KITTITAS COUNTY
DEPARTMENT OF PUBLIC WORKS

July 1, 2005

RE: Vista View Estates

The Kittitas County Department has reviewed the application for the Vista View Estates and submits comments for consideration in establishing a threshold determination. Prior to establishing the threshold determination I would recommend the applicant be afforded the opportunity to review the comments and meet with staff if there are points that require clarification or modification based upon mutual agreement of the issues.

VISTA VIEW ESTATES PTN. SE 1/4 OF SECTION 1, T.17N., R.18E., W.M. KITTITAS COUNTY, STATE OF WASHINGTON

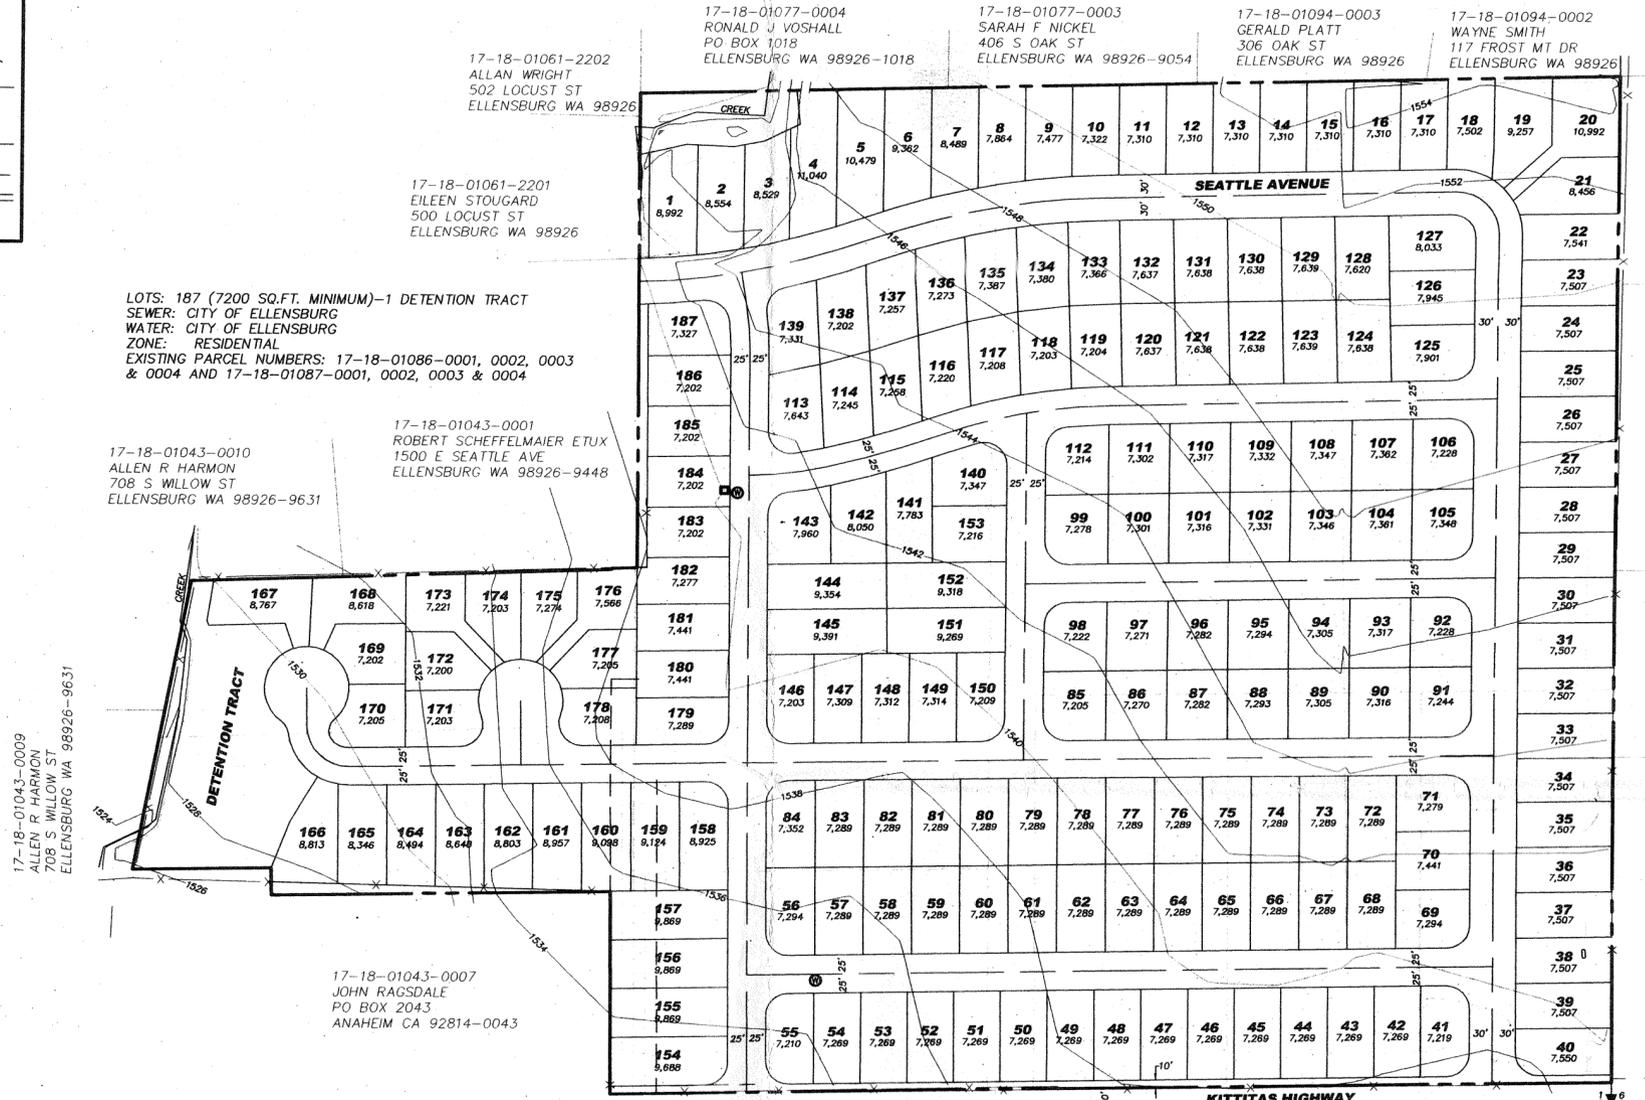
Half Street improvements including sidewalk, curb, gutter, storm drainage and street lighting will be required along Kittitas Highway along the frontage property. The future build out of Kittitas Highway will be a 44-foot face of curb to face of curb roadway. These improvements will be installed prior to annexation into the city or prior to completion of phase four, which ever is earlier.

The design standard for the internal residential streets shall be a 50' right of way width with a 38' roadway to face of curb and 5' wide sidewalks on each side, providing for 6" from the back of sidewalk to the property line. The improvements also include street lighting and storm drainage.

Lots 40 through 55 and Lot 154 shall not access Kittitas Highway, access shall be on the internal road system.

In addition to the Seattle Avenue right of way connection, a road right of way shall be stubbed out to the north boundary line for a future connection to Oak Street.
